## Honeycutt Hills Community - Lot 13

Townsend Model – Elevation 2

### 2<sup>nd</sup> Floor Framing — Rear 10' x 8' Sliding Glass Door Header

M+K Project #: 126-23047

2ND FLOOR FRAMING PLAN
SCALE: 1/8"=1'-0"

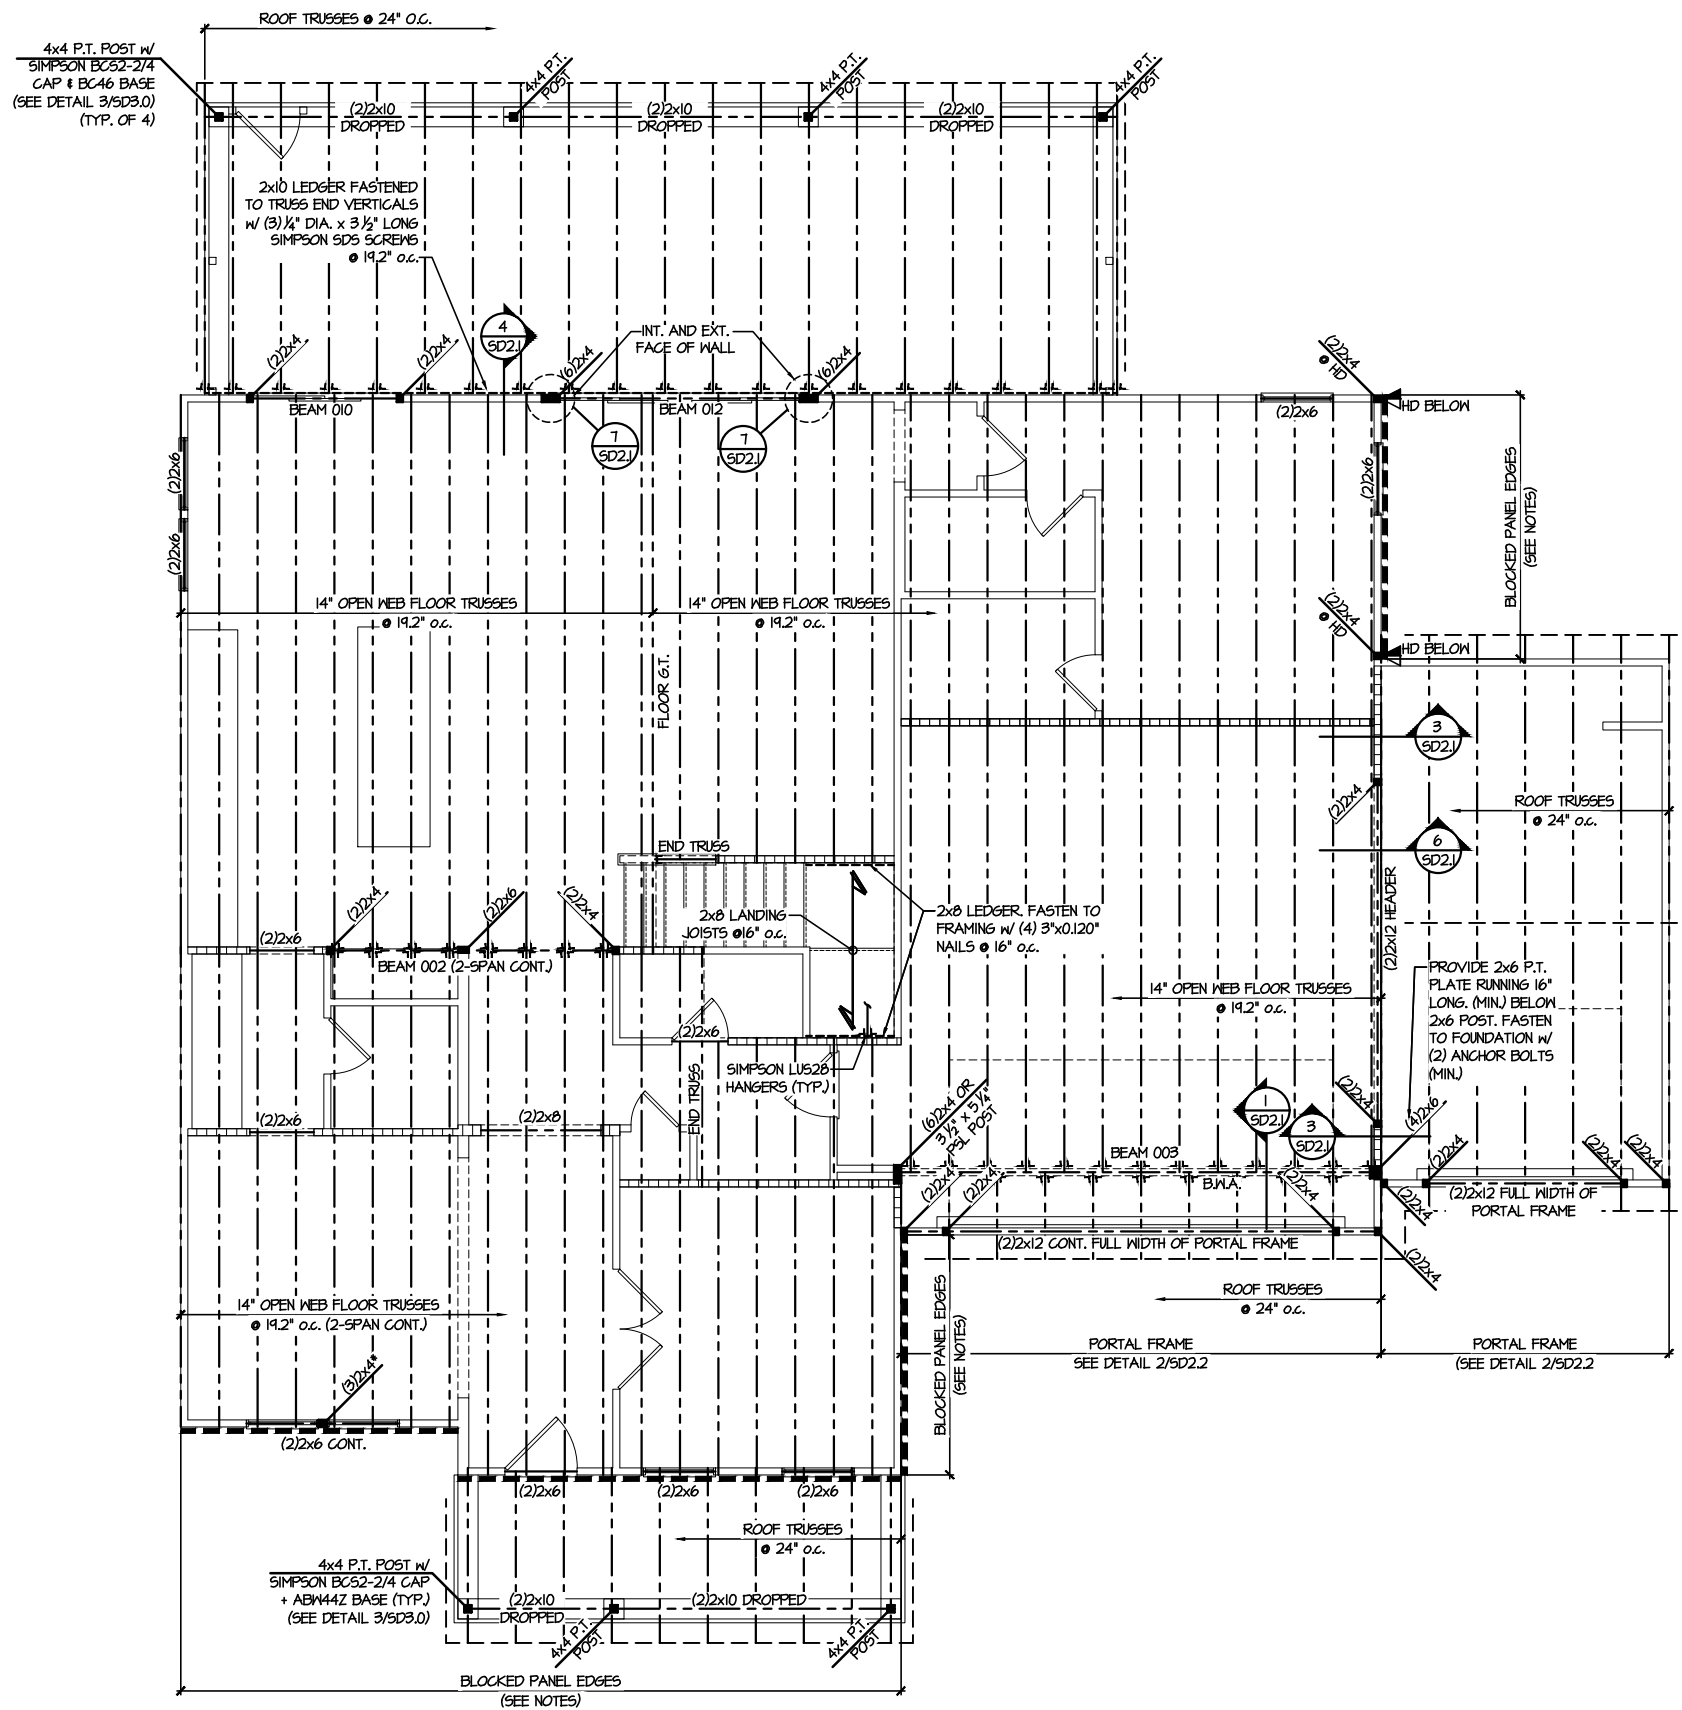
Pursuant to your request, we have prepared this letter to address the 2<sup>nd</sup> floor framing plan at the rear 10' x 8' sliding glass door header. It was reported to us, by you, that with the (2) 1 3/4" x 14" LVL header that is called out on the structural plans there is not enough clearance to install the door below.

We have analyzed the rear 10' x 8' sliding glass door header for a (2) 1 3/4" x 11 1/4" LVL in lieu of the (2) 1 3/4" x 14" LVL that is called out on the structural plans, and it is our professional opinion that the shallower 11 1/4" header is adequate to support the code required loads. The existing header may be removed and replaced with the shallower sized header. Alternatively, the bottom of the existing header may be notched for the installation of the door as required (2" maximum). Contractor is to start notch at corner of door opening below with a 1" diameter hole drilled prior to making straight cuts. Contractor must not over cut notch. Existing horizontal straps shall be removed and adjusted to new depth of notched beam. Provided additional blocking as required for adjusted horizontal strap connection.
